drawing
**PROPOSED REFUGE VEHICLE
 TACKING AND ACCESS DETAILS**

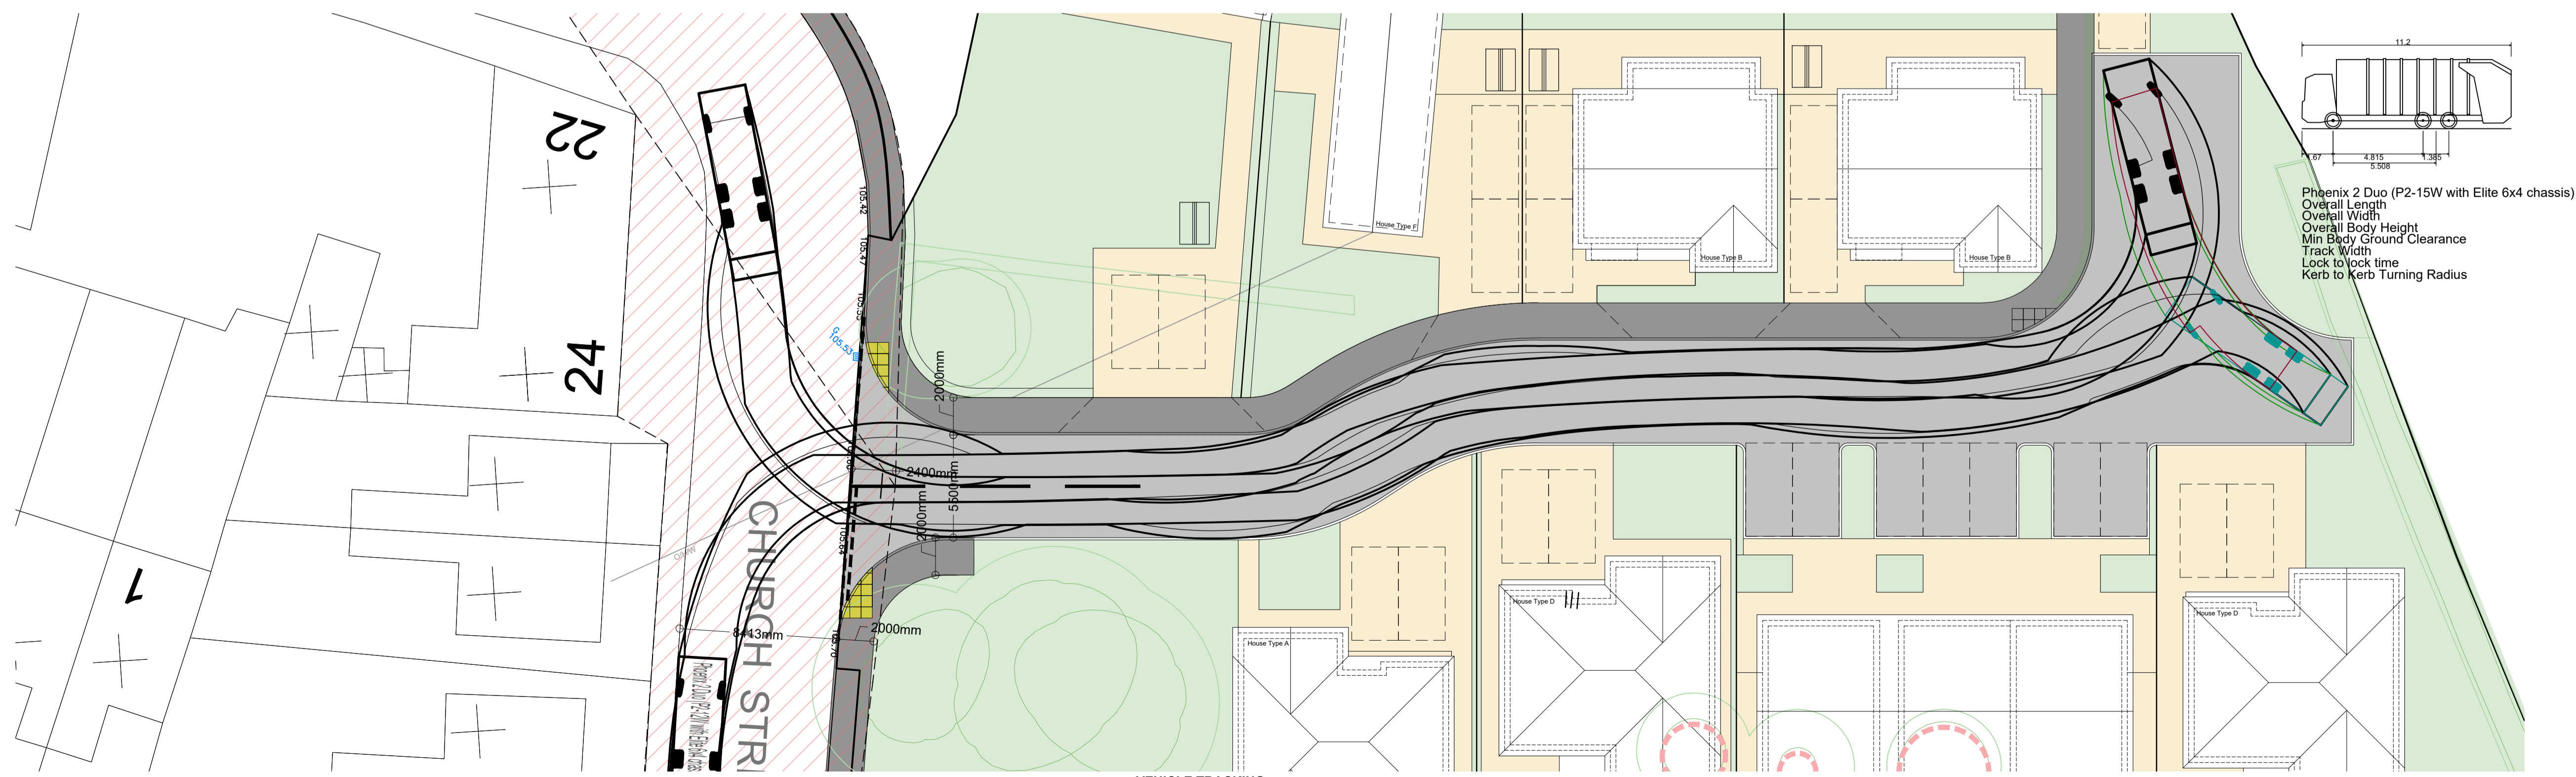
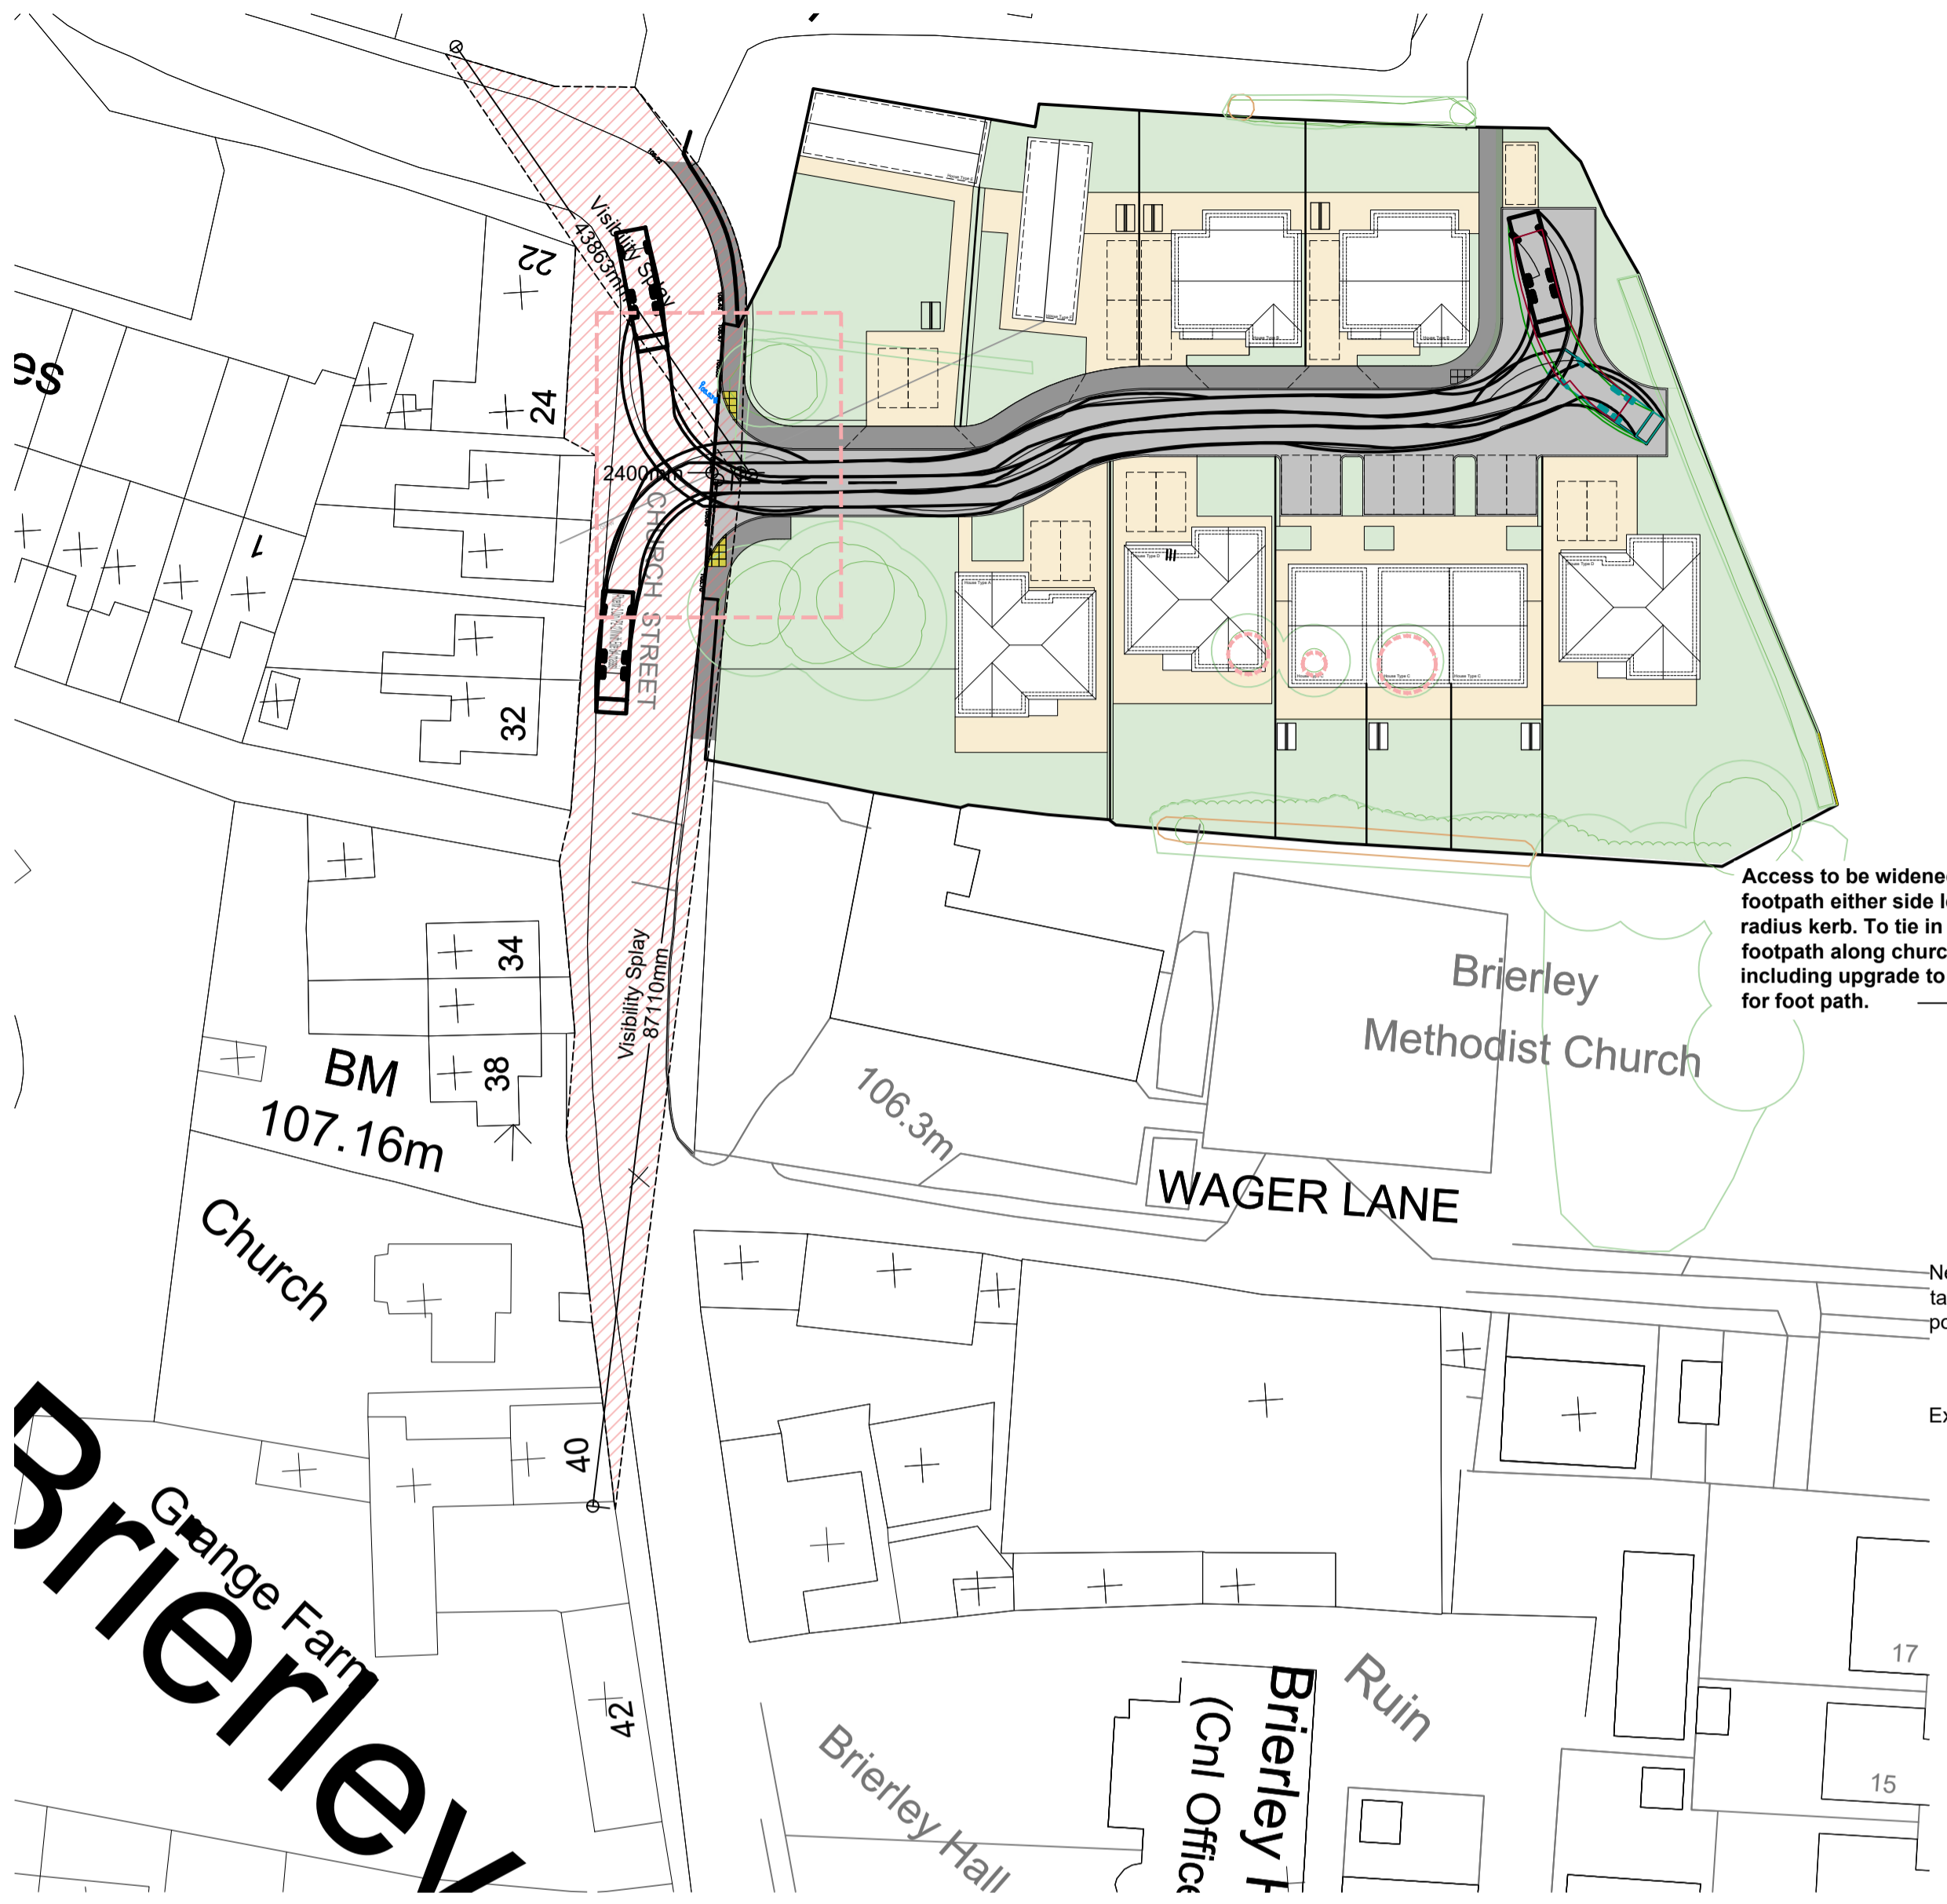
- Building for a Healthy Life Assessment required as per local validation checklist;
  - Please see attached requested assessment.
- Access appears overly wide but need to check with highway requirements;

**Highways DC** - Further information required, tracking for large refuse vehicles has not been provided. Amendments to layout required:

- No visitor parking proposed;
- A 2m distance between turning area and boundary treatments;
- Improved footways along site frontage;
- Compliance with Stage 1 Road Safety Audit;

- Query regarding possible further development;
  - No discussion has been had with the Client or Local authority in relation to a further development. The road leads up to the boundary to achieve the require turning head for Large refuse vehicles as requested by Highways. Additional planting and the removal of the path and 1.8mm fence has been implements to soften the boundary.

- Access is to comply with splays, refuse vehicle turning circle and to achieve safer egress into the site, no comments from highways has been put forward in relation to the width of this access.

Requested Information has now been provided
